Our ref: DOC20/326054

Request for additional information comments for Young High School and Joint-use Community Facility (SSD 9671)

This proposed SSD is within the curtilage of an active State Heritage Register (SHR) nomination, the *Lambing Flat Anti-Chinese Riot Site and Associated Banner*. The Heritage Council of NSW resolved, at its meeting of 3 March 2020, to give notice of its intention to consider listing this site on the SHR in acknowledgement of its heritage significance to the people of NSW. As part of the statutory listing process an exhibition period was held between 11 March and 8 April 2020. The submissions received during this exhibition period will be presented to the Heritage Council at their 2 June 2020 meeting when they will consider whether or not to recommend to the Minister that this item be listed on the SHR.

Figure 4 | Approved site plan (Source: SSD 9671 Approved Plans 2020)

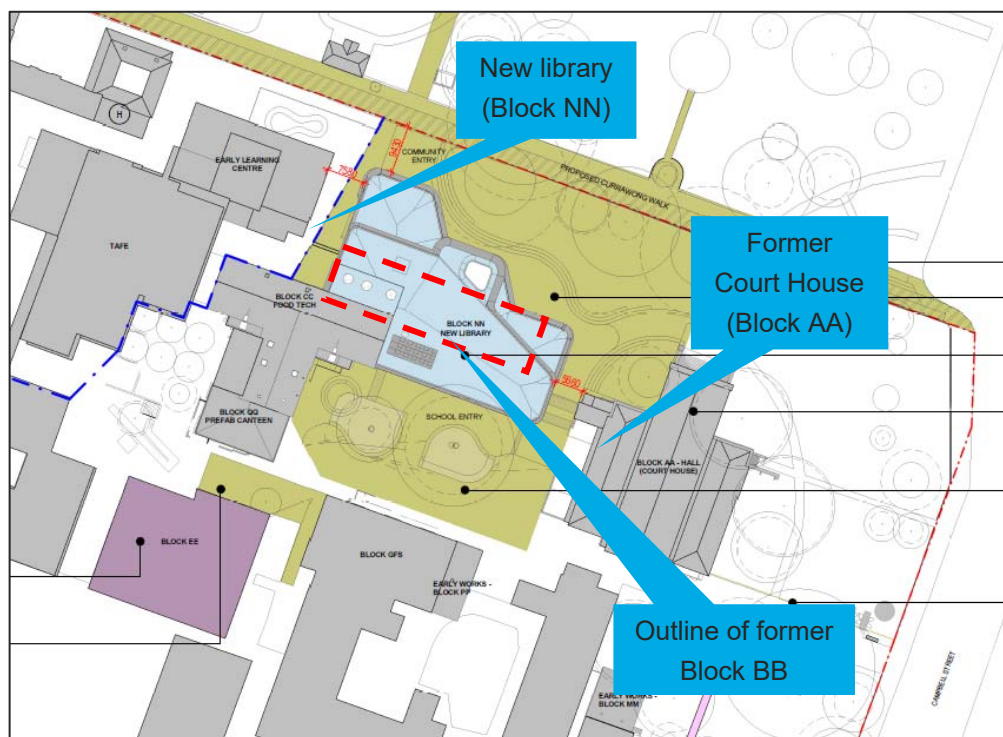
3. New Block NN Design

The Applicant has explained that the design of the New Block NN including setback and form are unable to be changed in the current application without a complete redesign of the project including functions and capacity within the buildings. The Applicant advised they may be able to lessen visual impacts through material and colour selection. The condition has been amended as follows to reflect this change. Heritage NSW clarifications to the Proponent's changes are set out in bold below:

The original purpose of this condition was to ensure that the Courthouse forecourt landscape design was refined to be in accordance with the assessed heritage significance of this area and the Courthouse. Our primary concern was the relationship between the Courthouse and the proposed Courthouse forecourt landscape design and this condition needs to reflect this. Heritage NSW did note the need for a transition from the new to the current landscapes during the 3 April meeting. However, this is only a potential solution to the larger issue.

The Heritage Council of NSW is generally supportive of the idea of incorporating Aboriginal cultural heritage values in the New Block NN landscape design. However, the landscaping should ensure that the values of the Courthouse are appropriately addressed in addition to other heritage values within the site. The Aboriginal cultural heritage values of the place are not currently under consideration at a State level in the SHR nomination. While they are an important site element, this aspect should not dominate the landscape design but work in tandem with other values. It is suggested that the landscaping and heritage interpretation strategy should speak to one another so that the landscaping incorporates interpretation in a meaningful way.

The design of the New Block NN is to be refined to reduce the visual impact of the proposed building on the setting of the historic Courthouse. **Where amendment to the setback and form of the New Block NN is not possible**, this may be achieved through review of material **and colour selection**. The final design drawings are to be provided to the Heritage Council of NSW or its delegate for review, and comments incorporated, prior to **the commencement of construction**.

The landscape design of the Courthouse forecourt is to be refined to ensure that it is consistent with the assessed heritage significance of the Courthouse and this part of the site. The significance of the Courthouse includes formalised landscaping elements, which are not well reflected in the current landscaping plan. The New Block NN Landscaping should better relate the values of the Courthouse including its setting. It should also appropriately consider the moderate to high archaeological potential of the area to the north and east of the Courthouse. The final design drawings are to be provided to the Heritage Council of NSW or its delegate for review, and comments incorporated, prior to commencement of construction.
